El Paso County Planning and Community Development

Re: Falcon Marketplace Preliminary Plan (SP-17-001) Response 6

Please accept this response letter to your review 4 comments dated August 27, 2018.

PROJECT NO. 20988-00CSCV  
DRAWING NO.  
**C7.3**

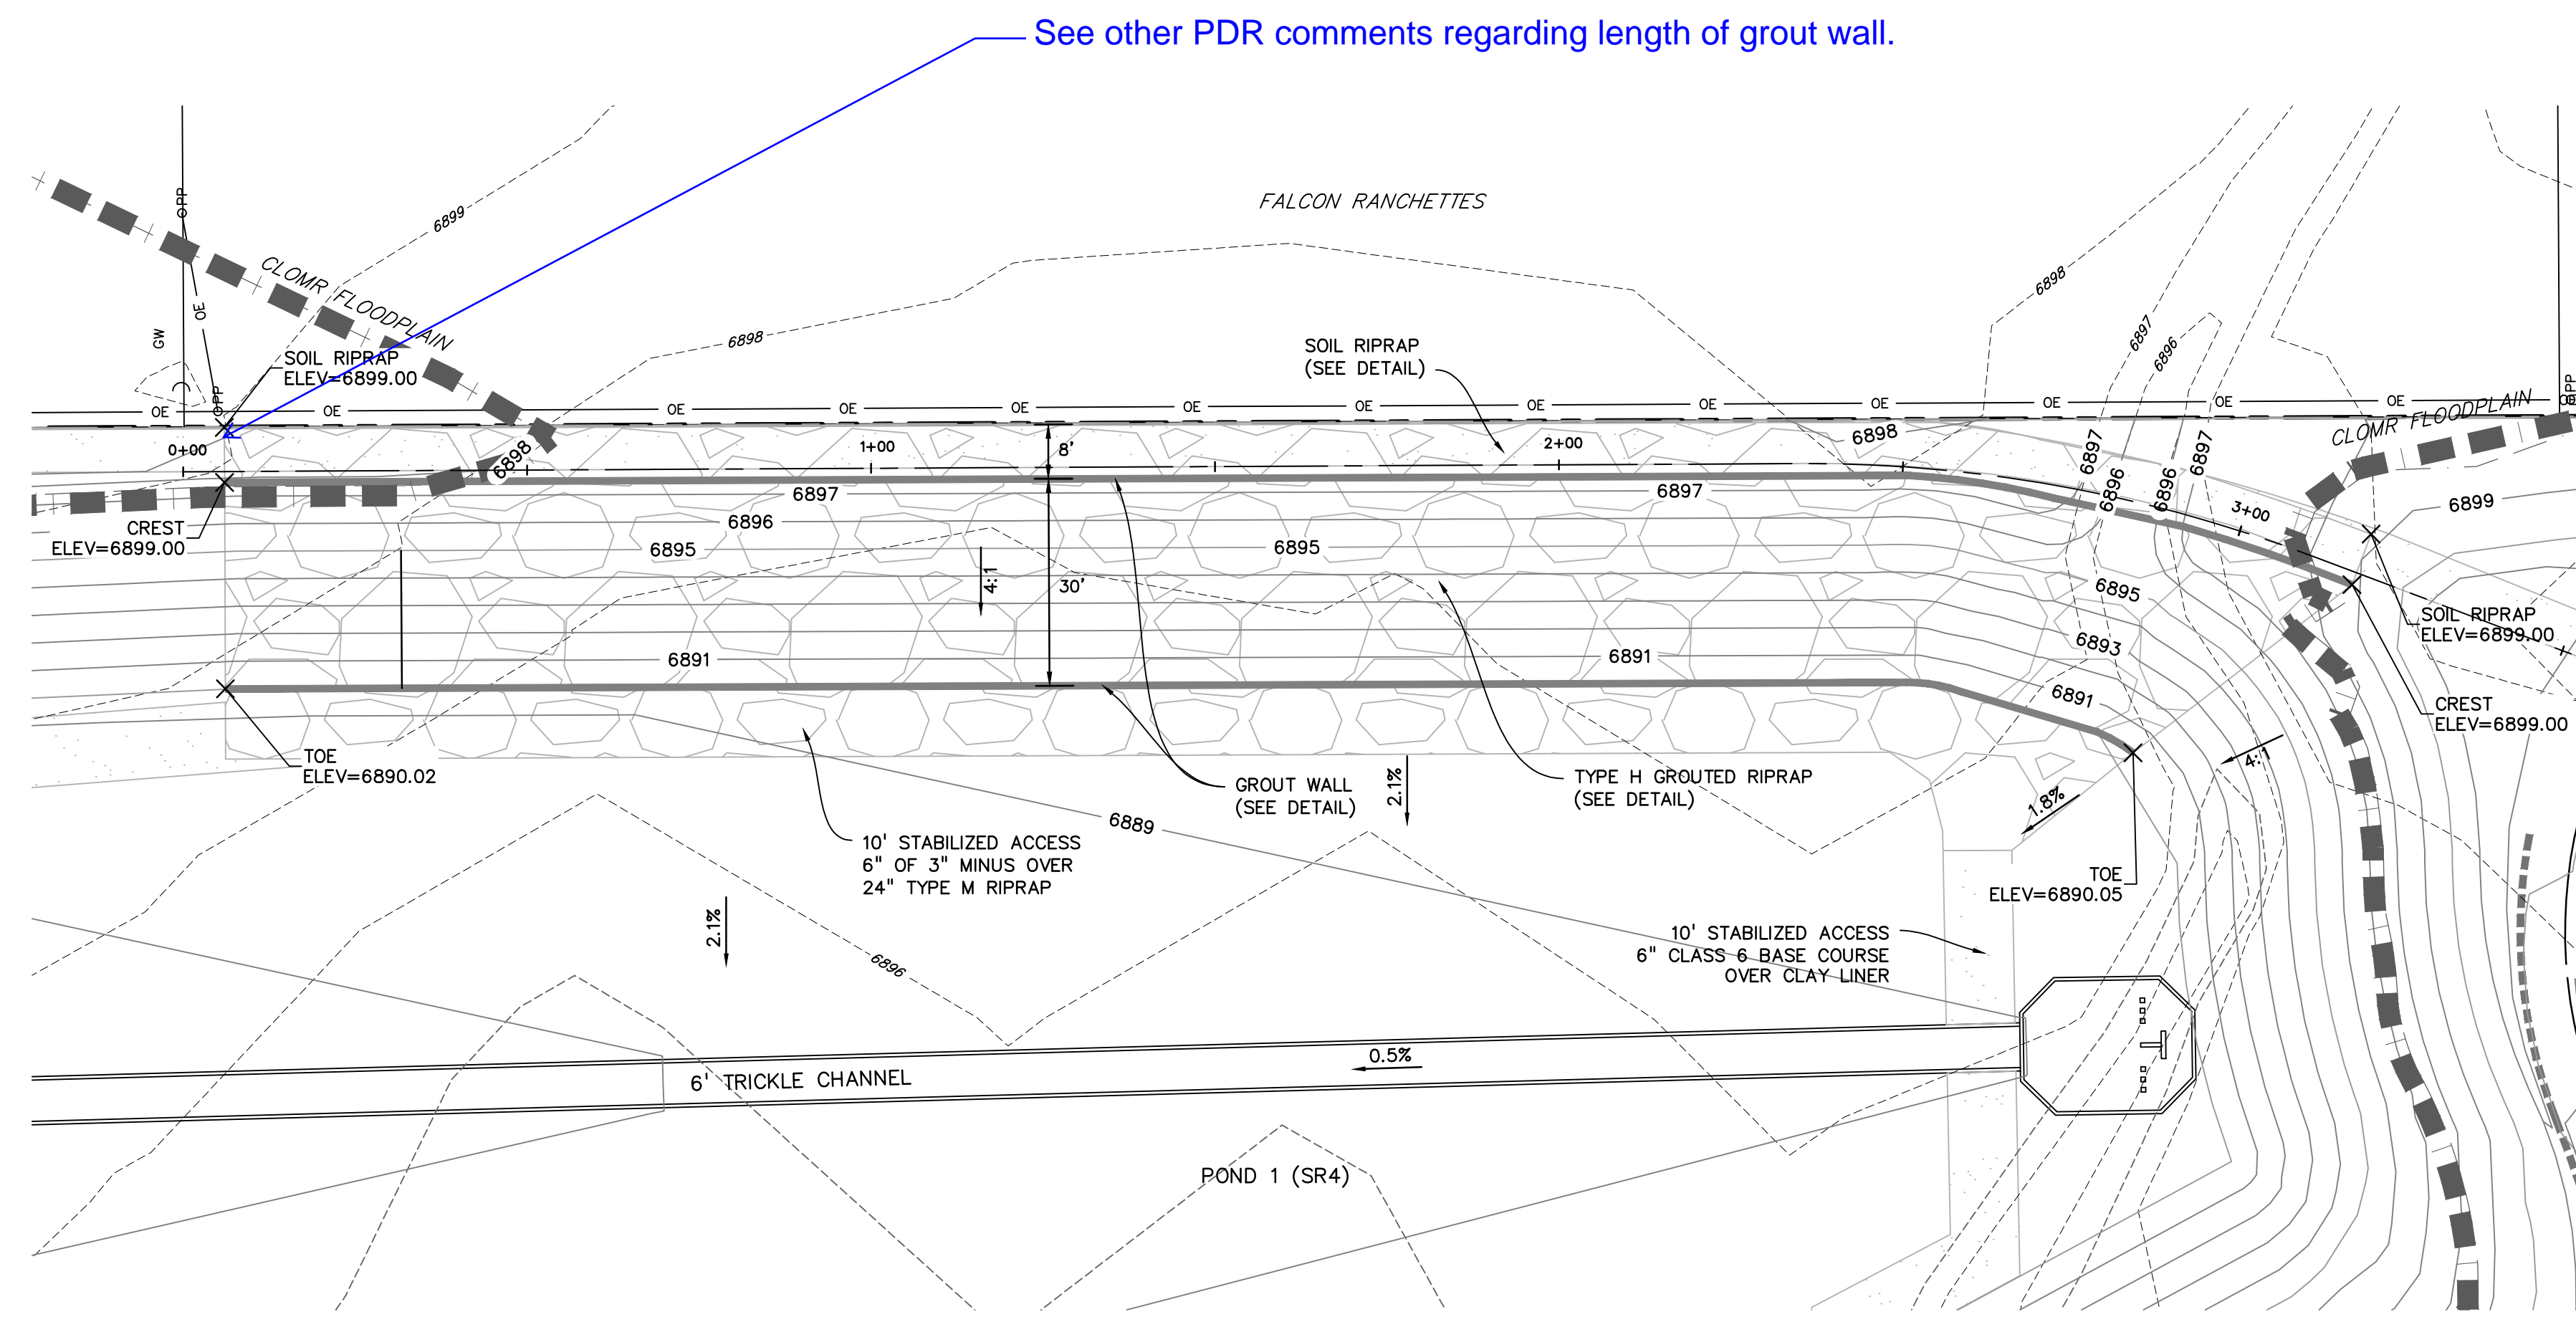
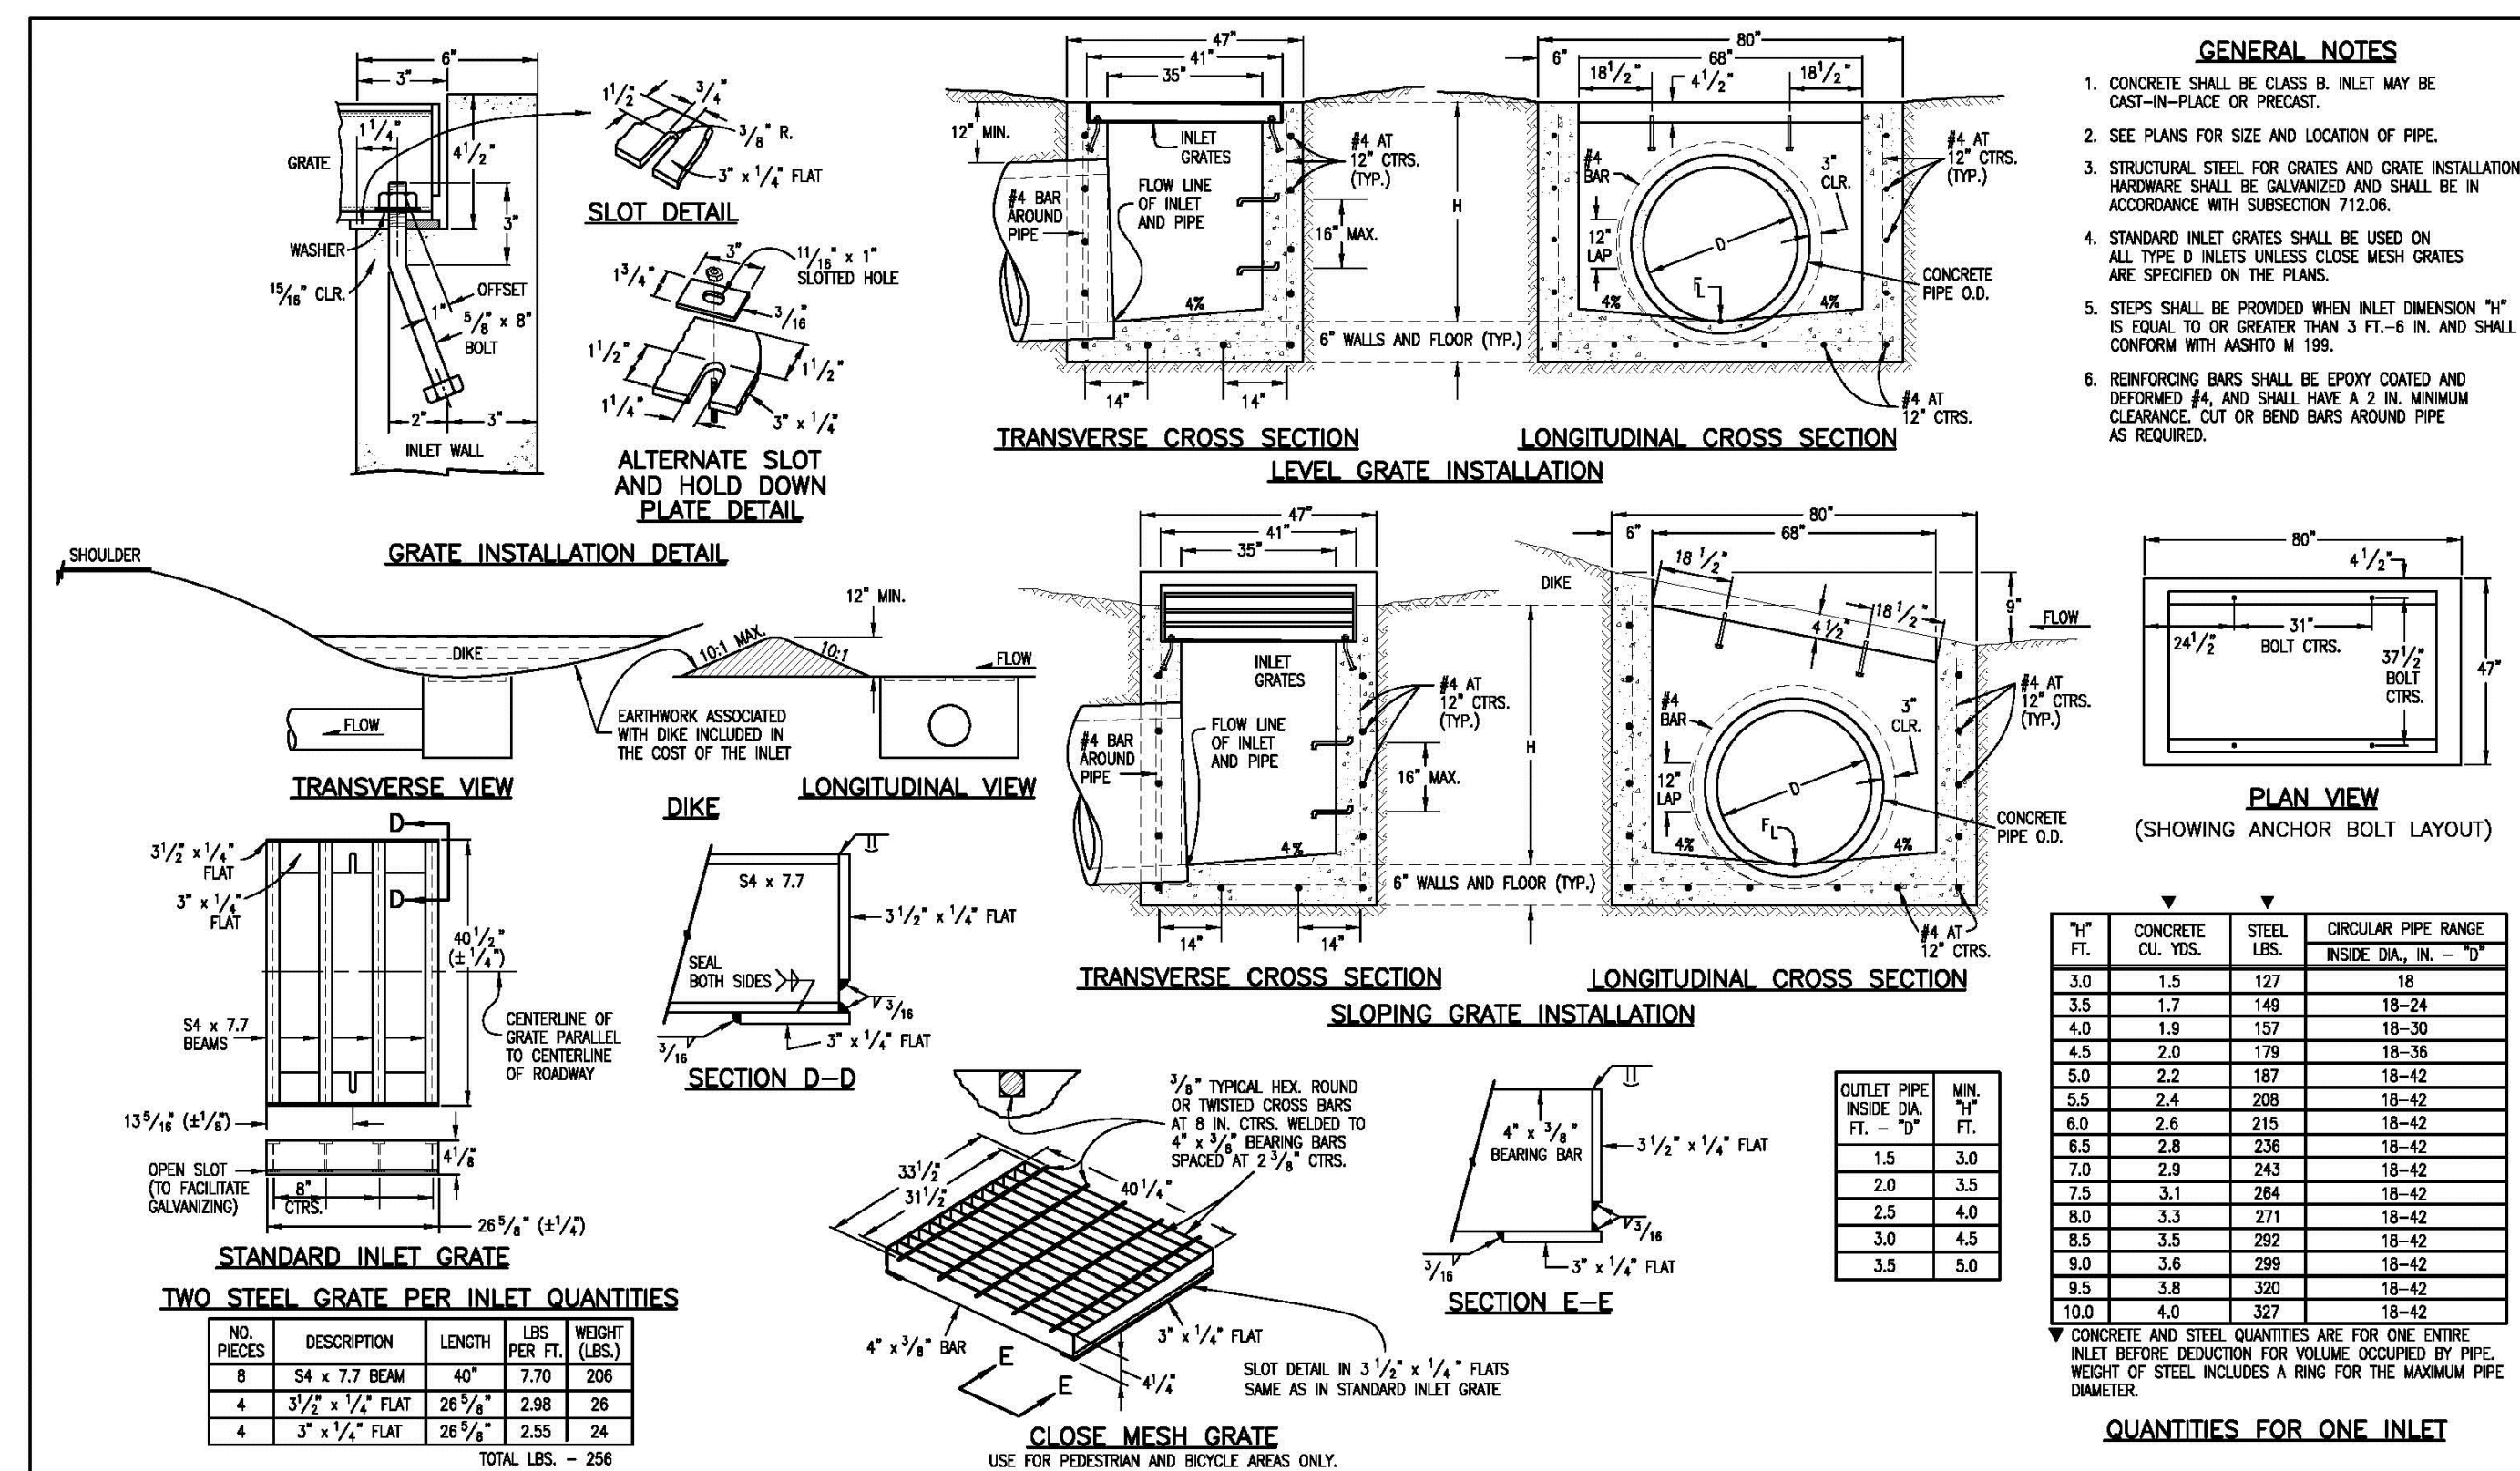
15. *Resolved*
16. *Reference attached UDFCD outlet structure design details. Specific items that need to be incorporated into the project's outlet structure designs include the orifice plate design and notes, water quality plate details (type and thickness), stainless steel well screen (page OS-9) and neoprene gasket. Complete review of sheet C7.9 will be provided after revisions. Sheets C7.11 and C7.12 will be reviewed with the subdivision CDs. Partially resolved; see redline regarding specific calculations for trash rack (now sheet C7.5). Partially resolved; see updated redlines.*
